**WELWYN HATFIELD BOROUGH COUNCIL  
EXECUTIVE DIRECTOR - PLANNING, PUBLIC PROTECTION AND GOVERNANCE**

**DELEGATED APPLICATION**

**Application No:** 6/2018/3182/FULL  
**Location:** 12 Harpsfield Broadway Hatfield AL10 9TF  
**Proposal:** Mixed-use development comprising of 8 student residential units (incorporating 21 study bedrooms), 169 sq.m of a4 commercial space(existing) with the associated on-site parking, pedestrian access, refuse and cycle storage  
**Officer:** Mr William Myers

**Recommendation:** Refused

DRAWING
PROPOSED ELEVATION

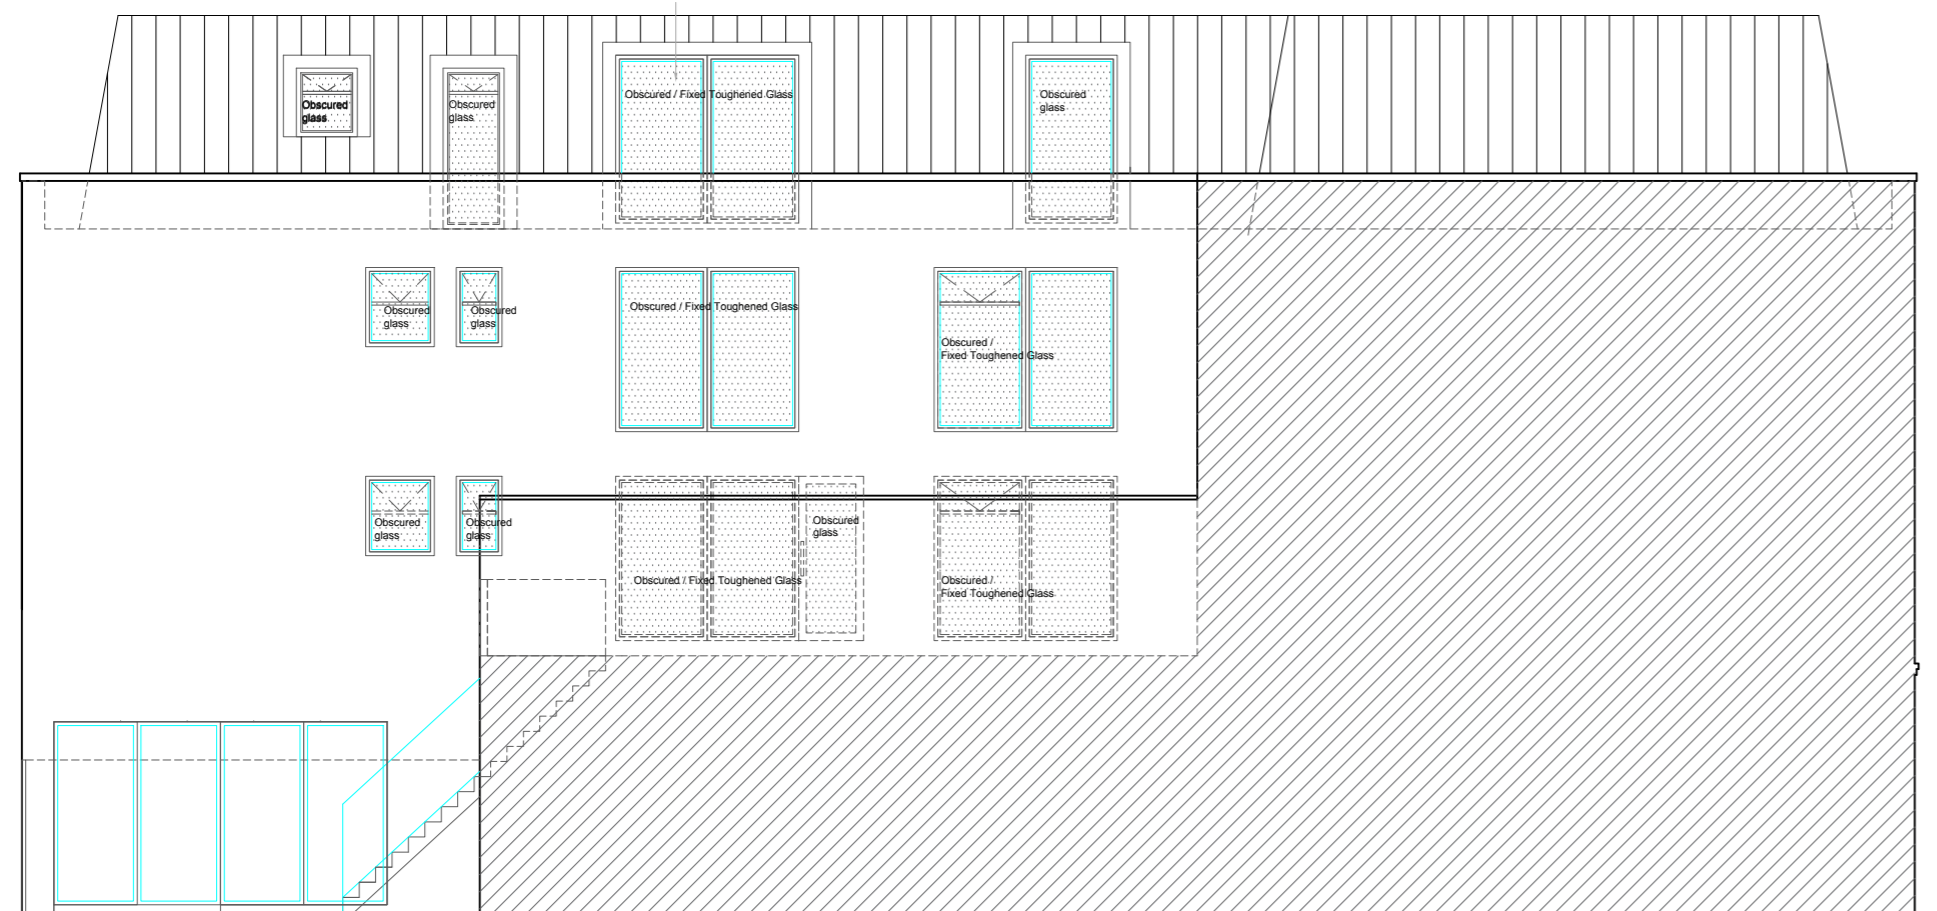
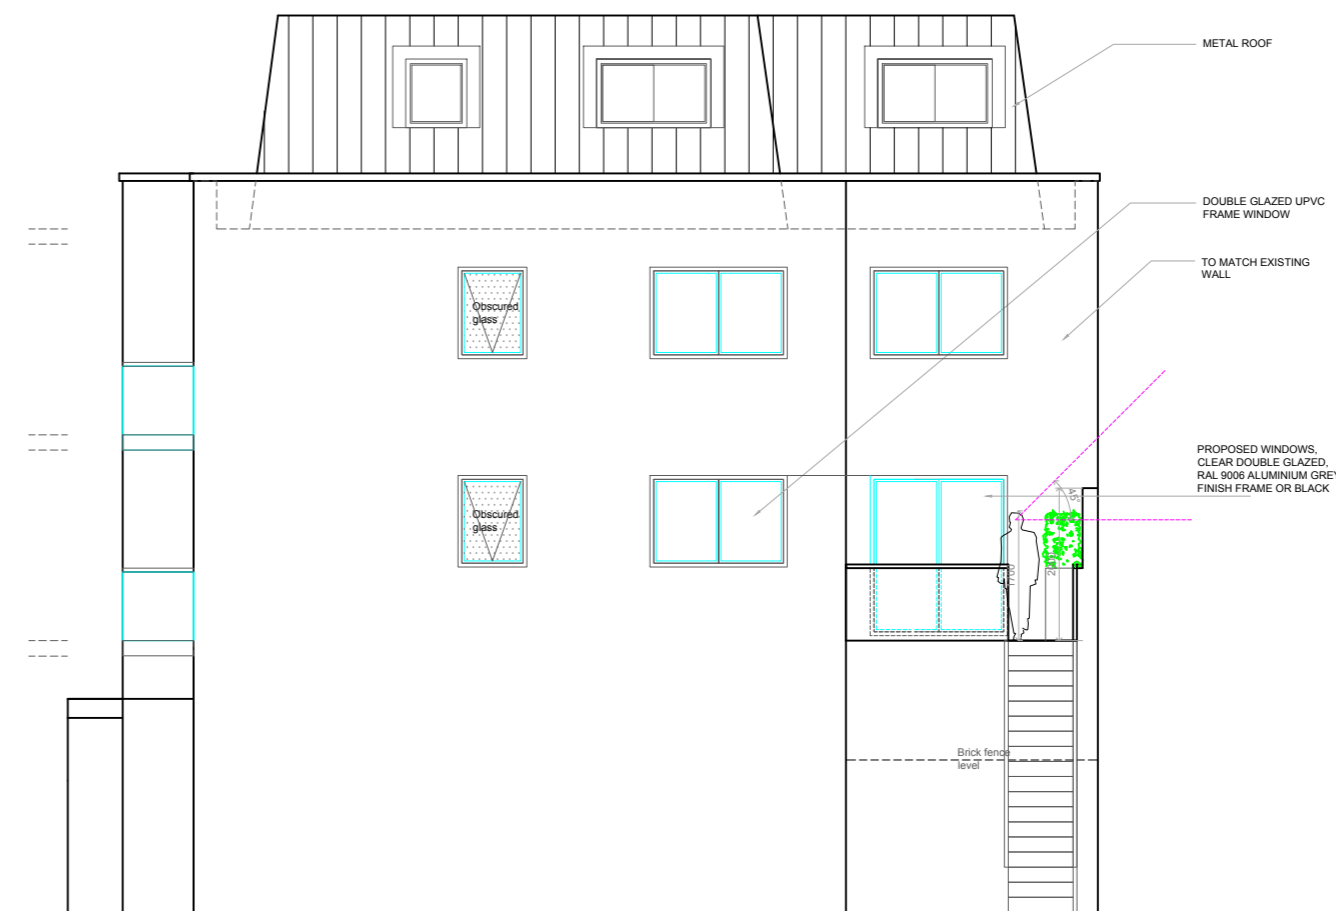
The proposed mansard roof reflects the adjoining terrace and is sympathetic in scale to its environment and to the original property. The roof extension would project approximately 1.8m above the existing parapet and would be set back approximately 600mm from the outside wall of the building on all sides. It is relevant that the visible bulk from public vantage points at ground level would be limited due to the height of the building and the set back.

A further inaccuracy within the submitted plans is that the floor plans appear to indicate an access into the bus station area to the rear of the site but the elevations do not show this. It is judged if a door is proposed within this elevation that such an access would be unacceptable because the door would open immediately onto a bus station. As a result such this layout and access arrangement would constitute poor design.
